Subject: RE: Y/152/20/RES - ADC Comments

Subject: Y/152/20/RES - ADC Comments

I am now able to write to you with our comments on the scheme as submitted. I am sorry it has taken some time to provide these. I honestly don't know where the time went.

9.15 DROVE PARK CHARACTER AREA -
FENESTRATION DETAIL

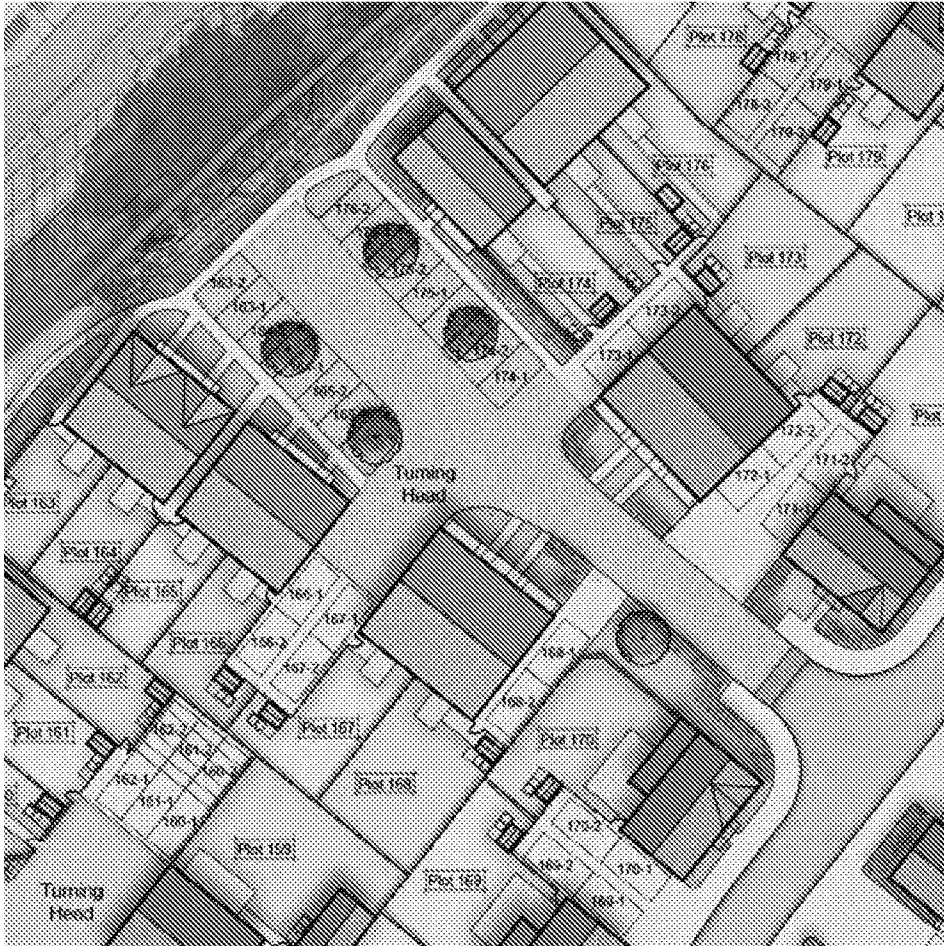
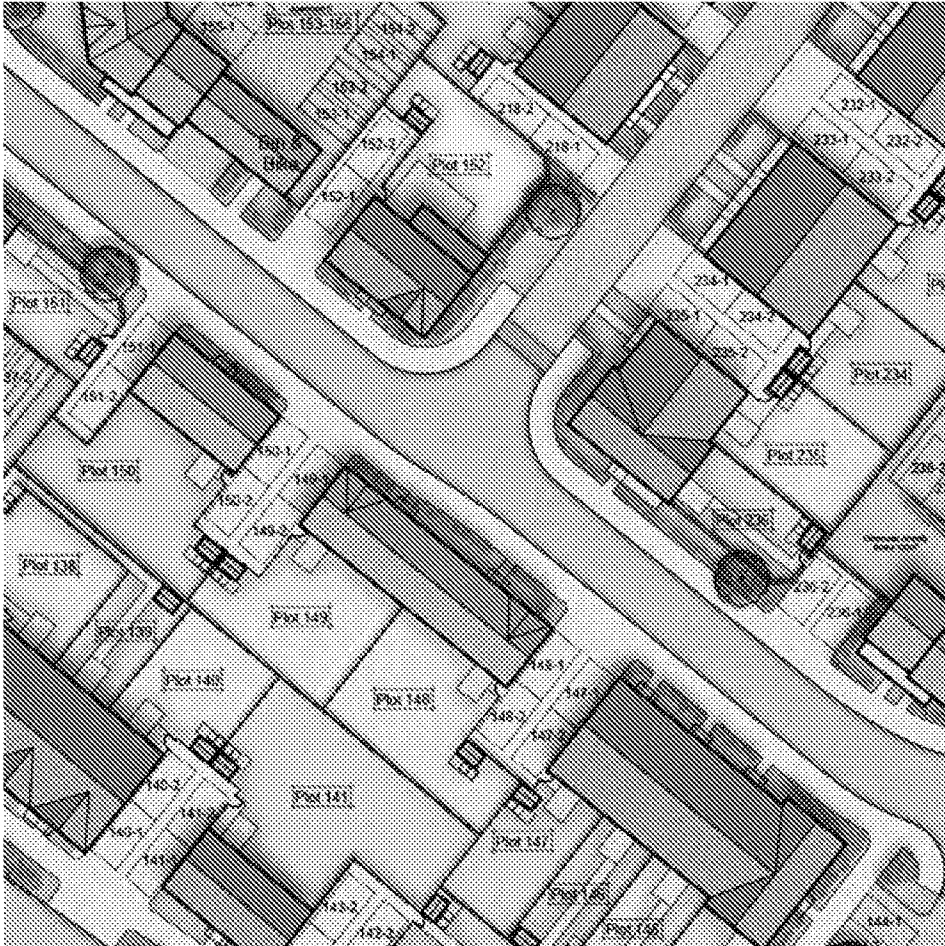
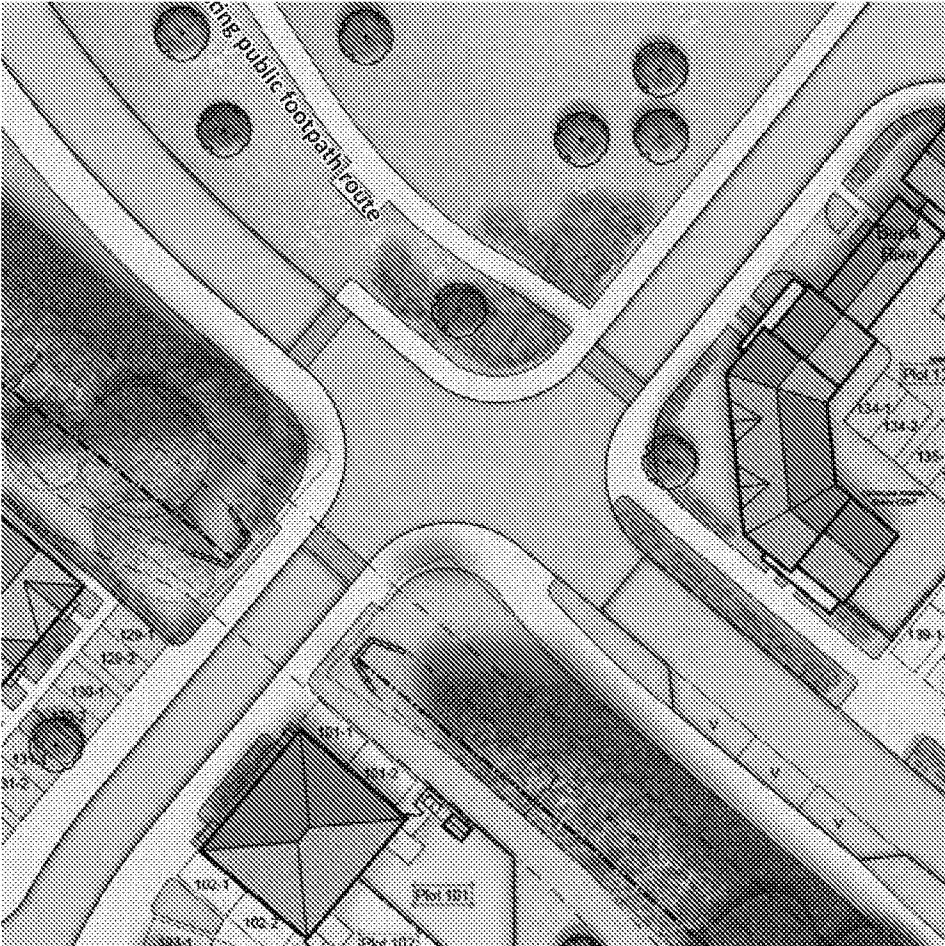
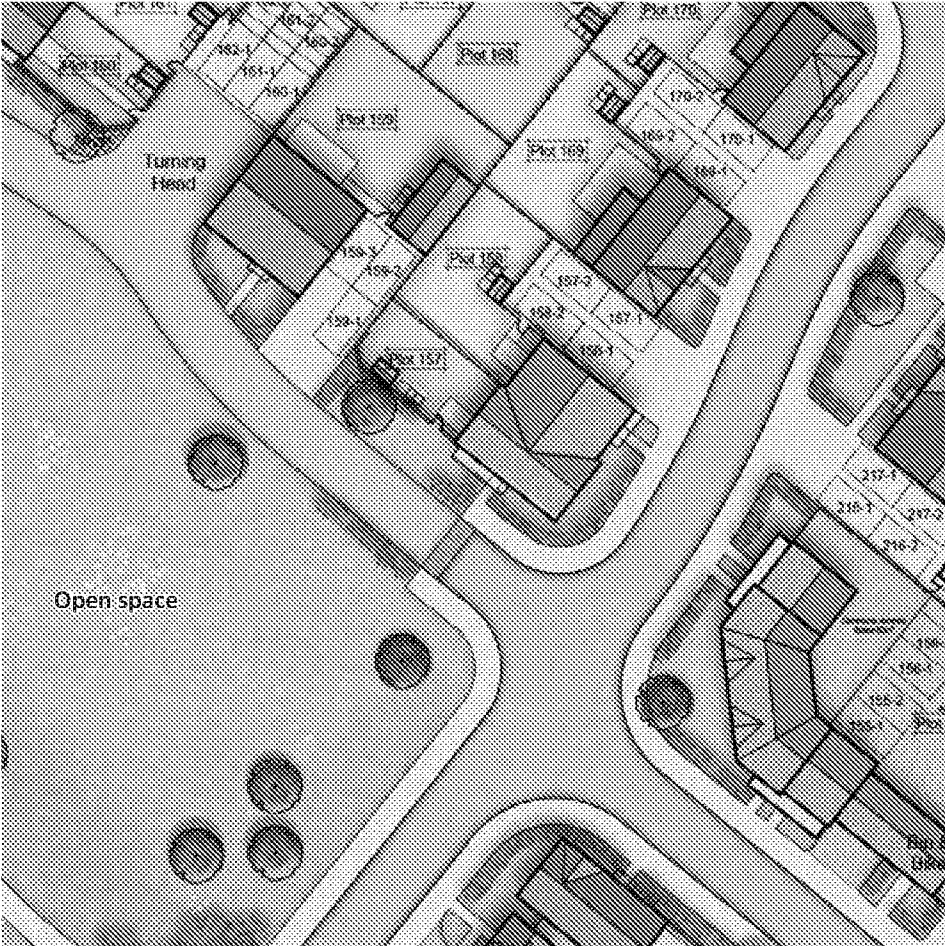
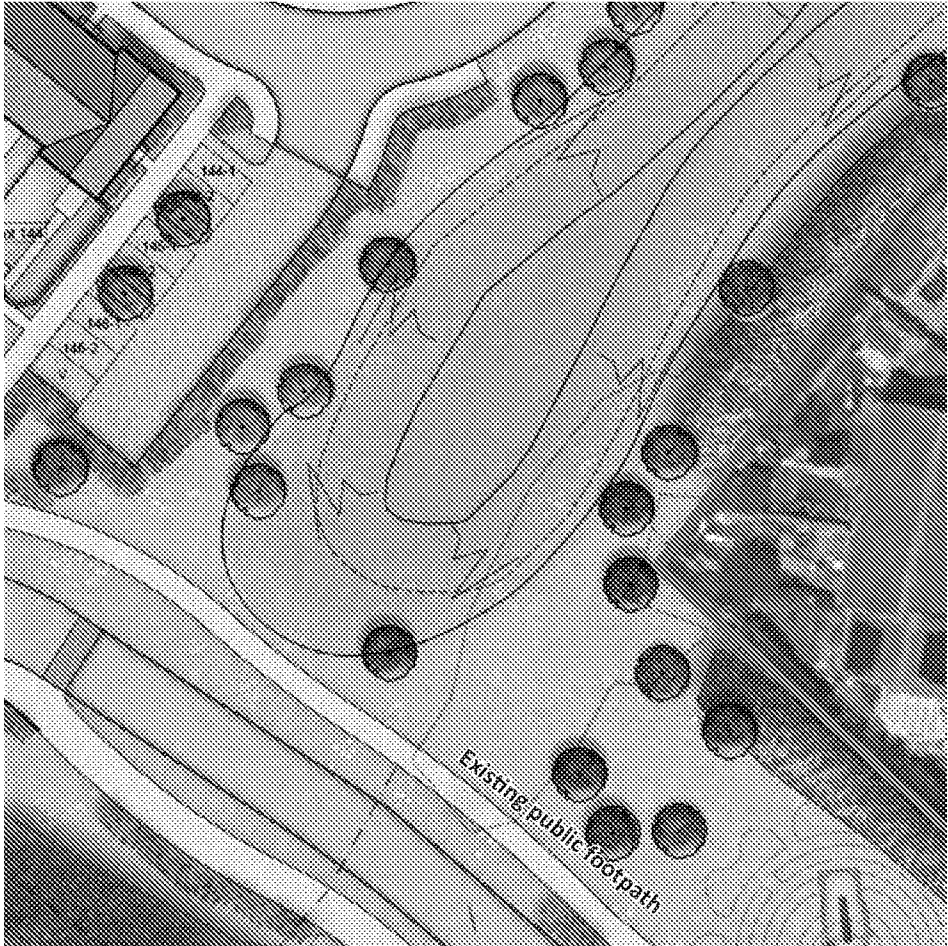
- (N) As per the Design Code, all 3 areas should have red/brown/grey roof tiles but the plans only show red/grey tiles in all 3 areas. In addition, the planning statement says that Loveys Field will have red/brown/grey tiles but that the other areas only red/grey.

- (O) The Design Code states that chimneys will only be provided in the Bilsham Street area but the layout also shows these in Drove Park.
